Pear tree Hill Solar Farm

Environmental Statement Addendum

Revision 2 (tracked)

Application Document Ref: EN010157/APP/8.2

Figure 14.3: Public Rights of Way and Long Distance Paths Within and Adjacent to the Proposed Development

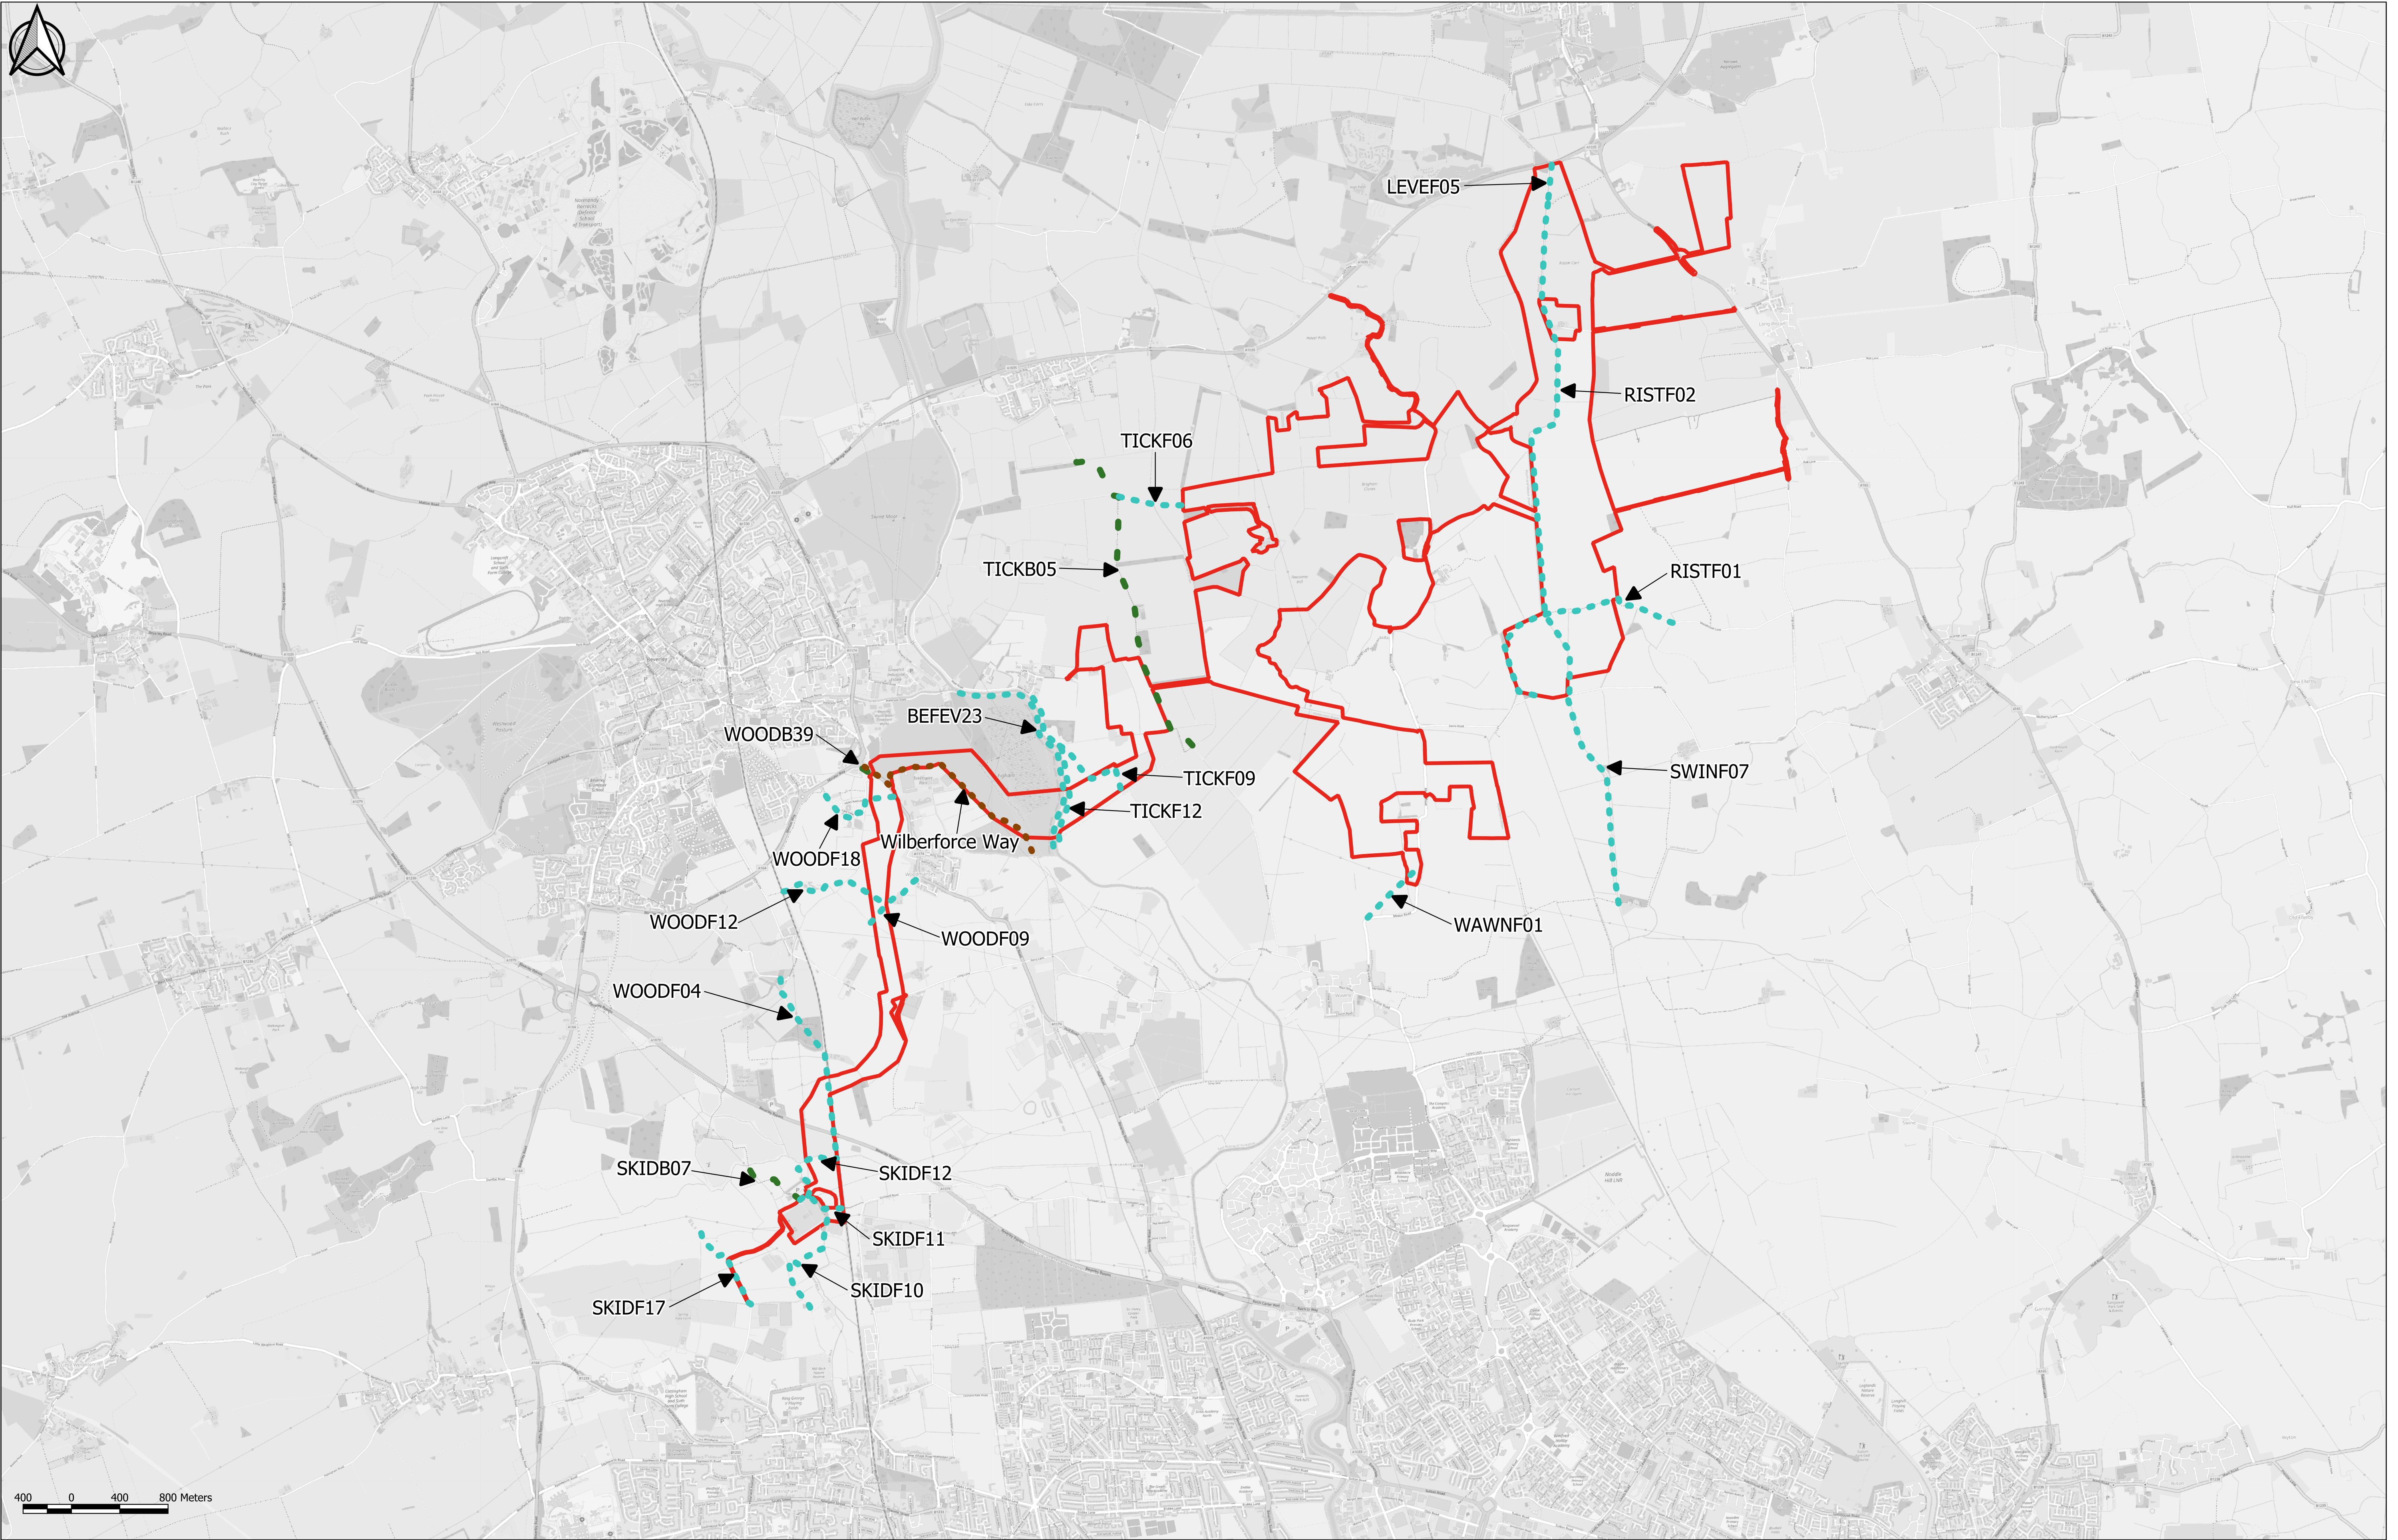
Document reference	Reason for amendment	ES Amendment July 2025
ES Volume 3, Figure 14.3: Public Rights of Way and Long Distance Paths Within and Adjacent to the Proposed Development [APP-091]	Figure 14.3 requires amendment to reflect the removal of plots 10-4, 10-5 and 10-6 as part of change/correction 2.	
ES Volume 3, Figure 14.4: Link Sensitivity [APP-092]	Figure 14.4 requires amendment to reflect the removal of plots 10-4, 10-5 and 10-6 as part of change/correction 2.	
ES Volume 3, Figure 15.1: Other Existing and/or Approved Development [APP-093]	Figure 15.1 requires amendment to reflect the removal of plots 10-4, 10-5 and 10-6 as part of change/correction 2.

#### Figure 6.1: Demolition (During Decommissioning Phase)/ Earthworks/ Construction Activities Study Areas

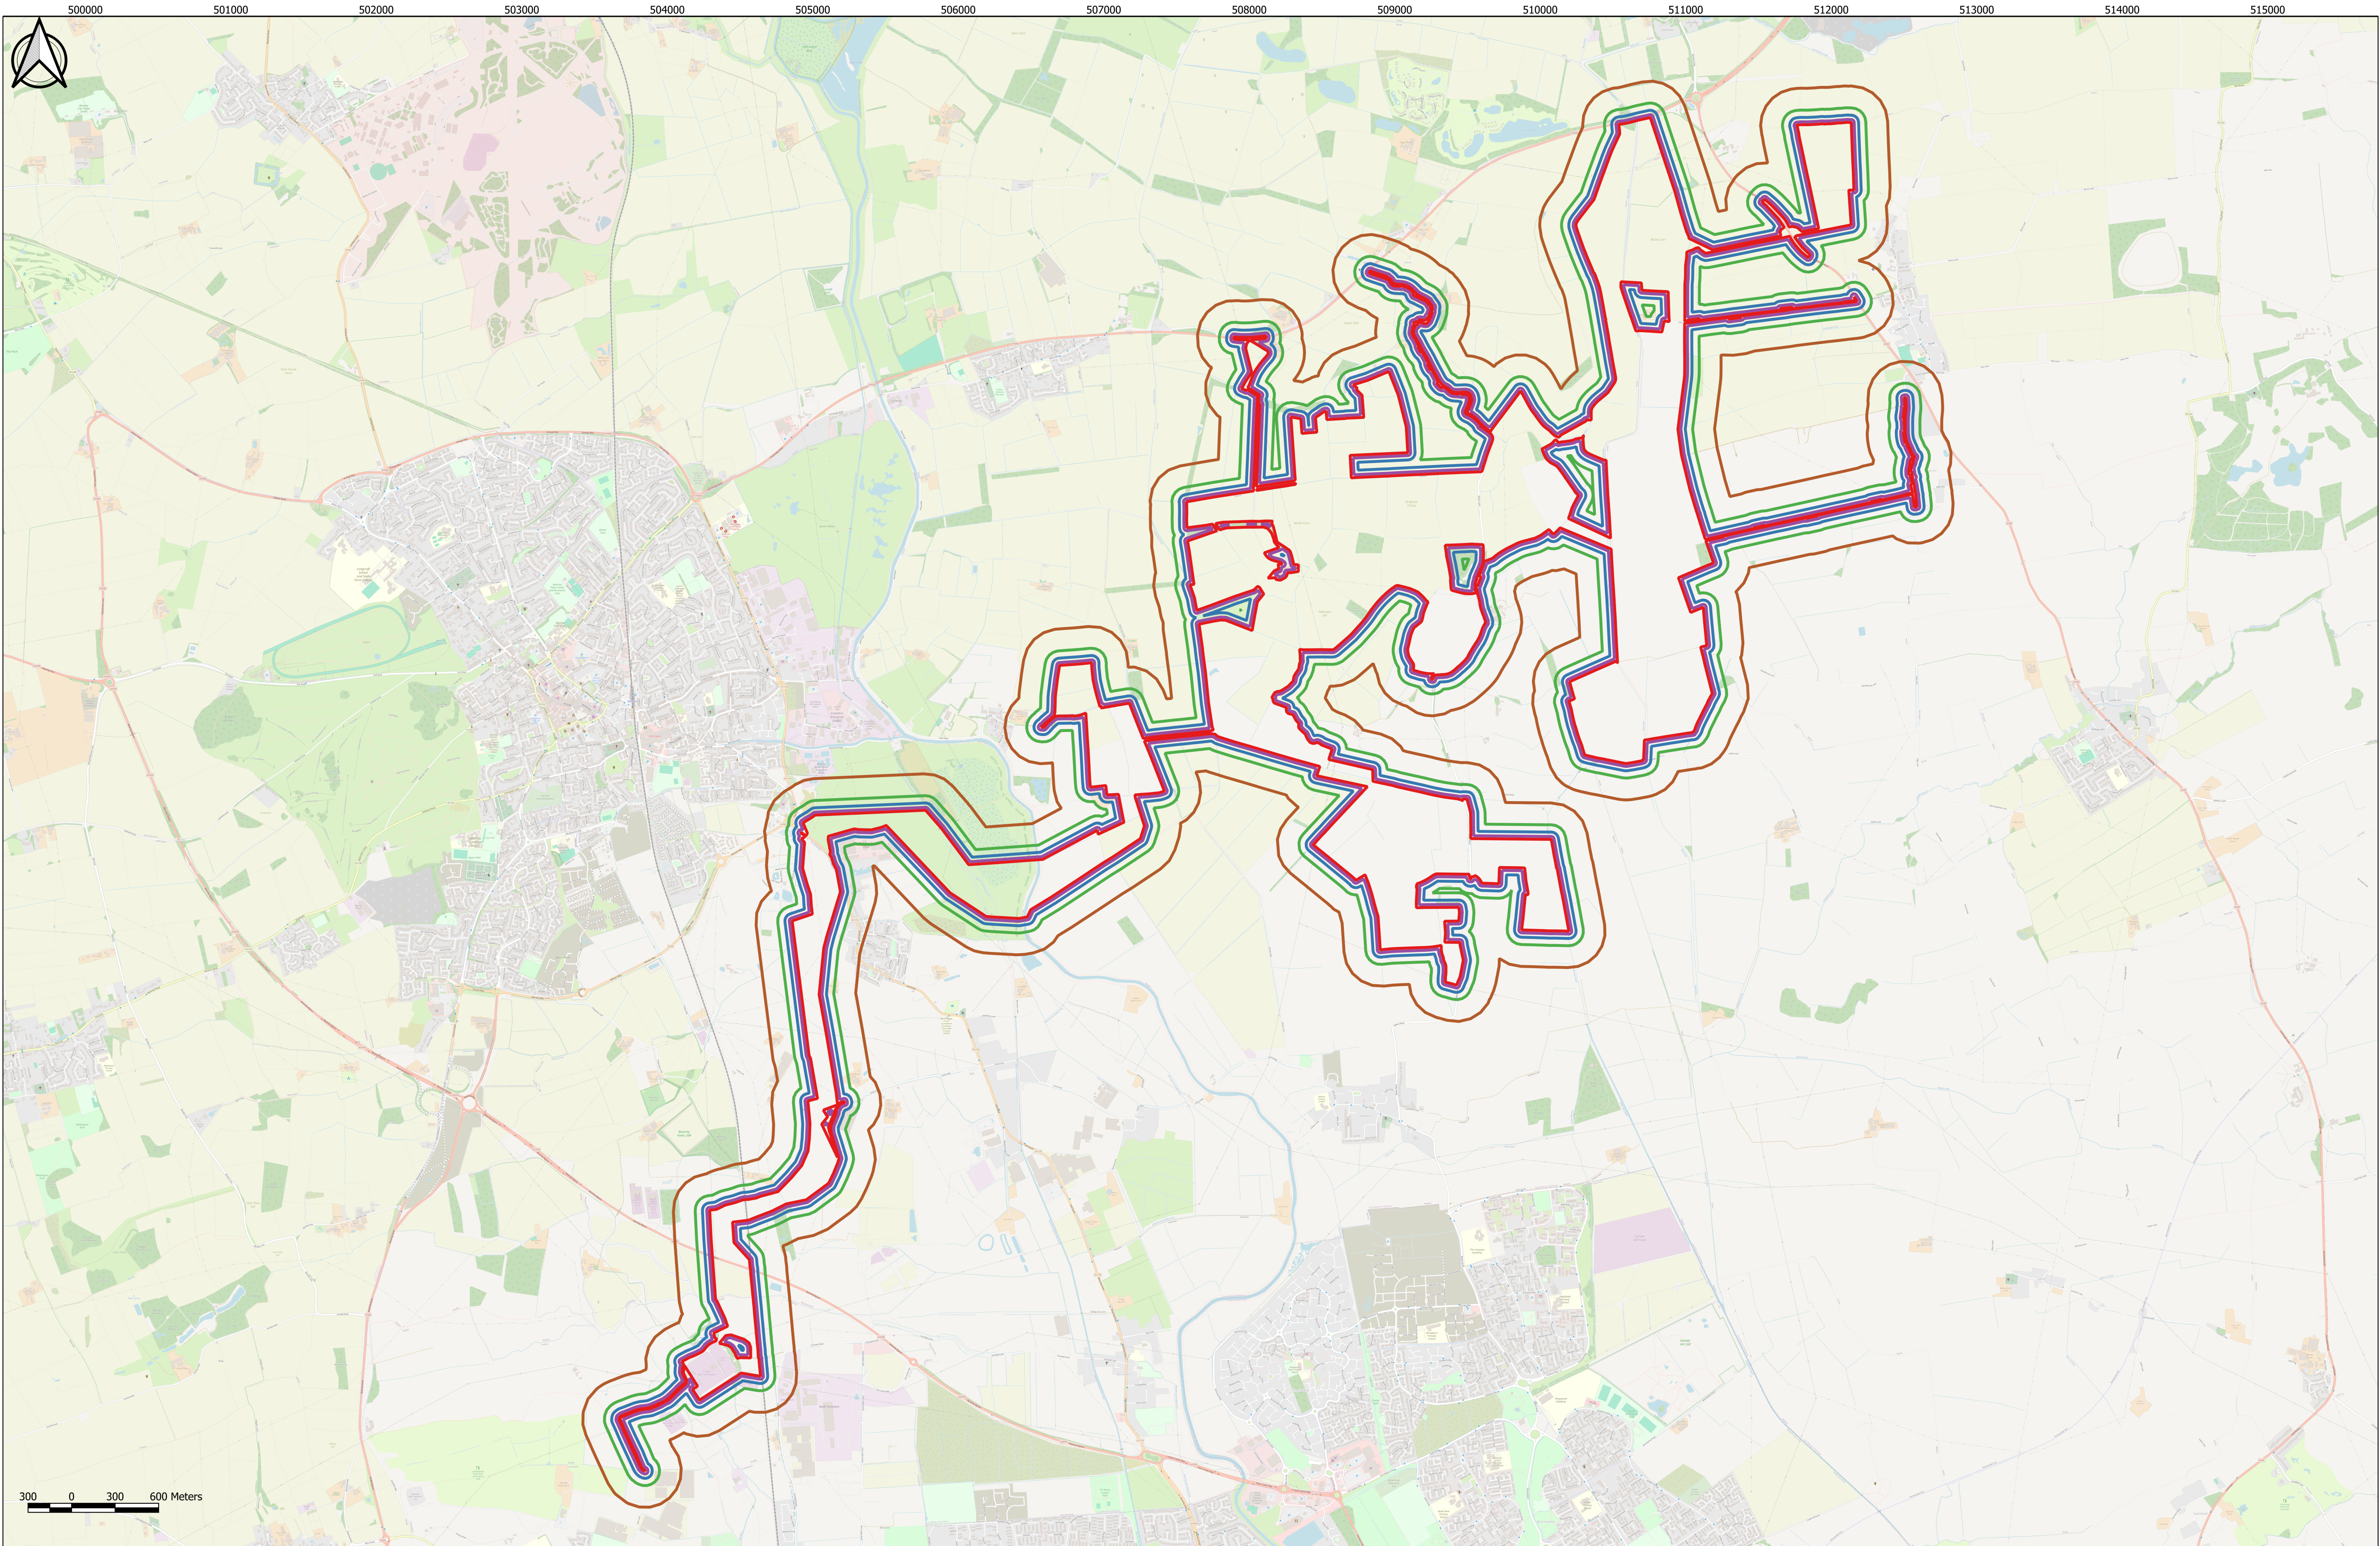
<p><u>ES Volume 3, Figure 7.1: Designated Sites and Ecological Mitigation and Enhancement Areas [APP-065]</u></p>	<p><u>Response to the ExA's First Written Questions [PD-008] (1.3.9).</u></p> <p><u>Points raised during engagement with Natural England regarding discrepancies in the hectareage of ecological mitigation and enhancement areas.</u></p>	<p><u>Figure 7.1 is amended to show the extents of Local Wildlife Sites (LWS) within or adjacent to the Order Limits. It is also amended to address discrepancies in the hectareage stated for ecological mitigation and enhancement areas in ES Figure 7.1 [APP-065] compared with the Outline LEMP [PDA-018].</u></p> <p><u>Resubmitted on 27 August 2025 as:</u> <u>ES Volume 3, Figure 7.1: Designated Sites and Ecological Mitigation and Enhancement Areas – Rev 2</u></p>
<p><u>ES Volume 3, Figure 14.2: Transport Routing and the Existing Highway Network [APP-090]</u></p>	<p><u>Response to the ExA's First Written Questions [PD-008] (1.13.6).</u></p>	<p><u>Figure 14.2 is amended to show connections between proposed Heavy Goods Vehicle (HGV) routes and with the wider road network, including the Strategic Road Network, more clearly.</u></p> <p><u>Resubmitted on 27 August 2025 as:</u> <u>ES Volume 3, Figure 14.2: Transport Routing and the Existing Highway Network – Rev 2</u></p>
